Date: 14-May-2024
Our Ref: 2023/93276

**Discharge conditions 3 (materials), 4 (improvements to access track and parking), 5 (waste collection) on previous permission 2021/94676 for erection of extensions and alterations to convert existing pig sty, domestic storage and WC building to single dwelling
Hey Knowle Farm, Linfit Lane, Linthwaite, Huddersfield, HD7 5LF
Application Number: 2023/93276**

title Site plan and location plan
number 20141D-05-P04
scale 1:200, 1:100 and 1:1250
size A1

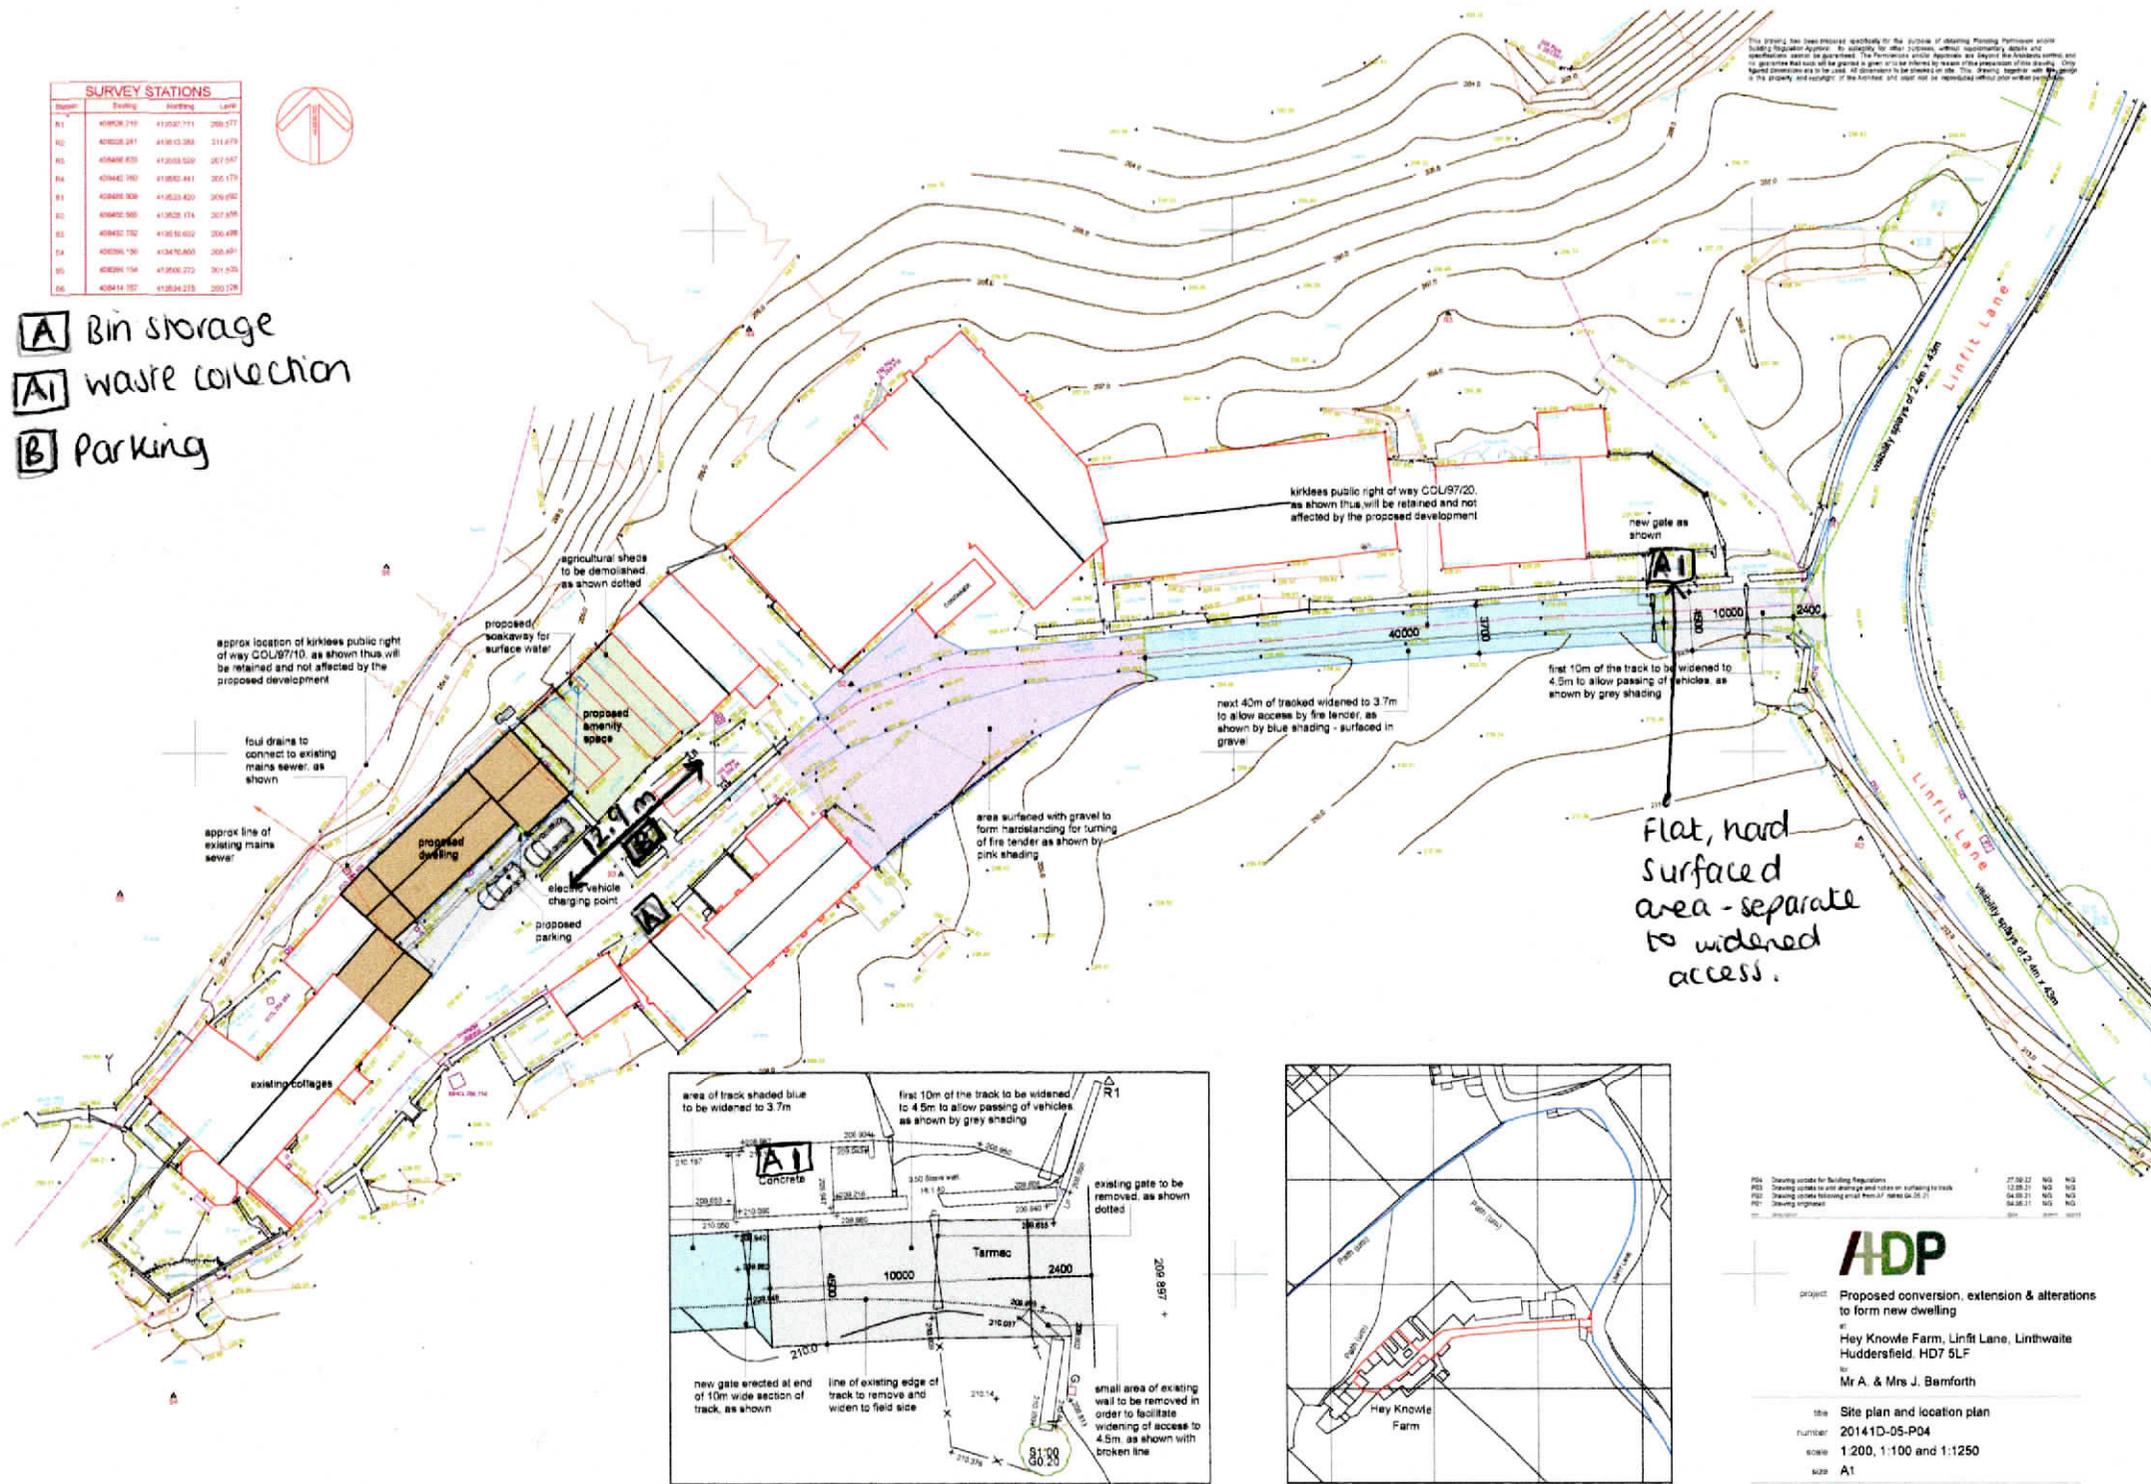
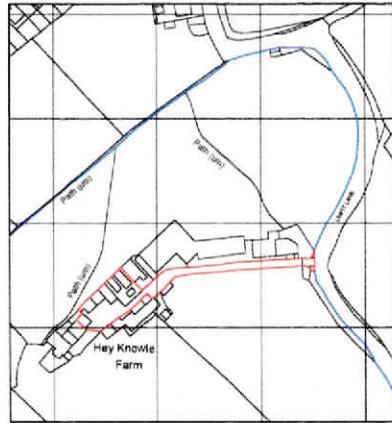
The details of the parking spaces and access track shown on the amended site plan submitted 12-Apr-2024 are considered acceptable and are hereby approved.

Please note all parking space should ensure that Public Right of Way COL/97/20 remains unobstructed at all times.

The details proposed bin storage facility and collection point as shown on the plan received 12-Apr-2024 are both deemed acceptable.

Please note that the bin storage facility and collection point should ensure that Public Right of Way COL/97/20 remains unobstructed at all times.
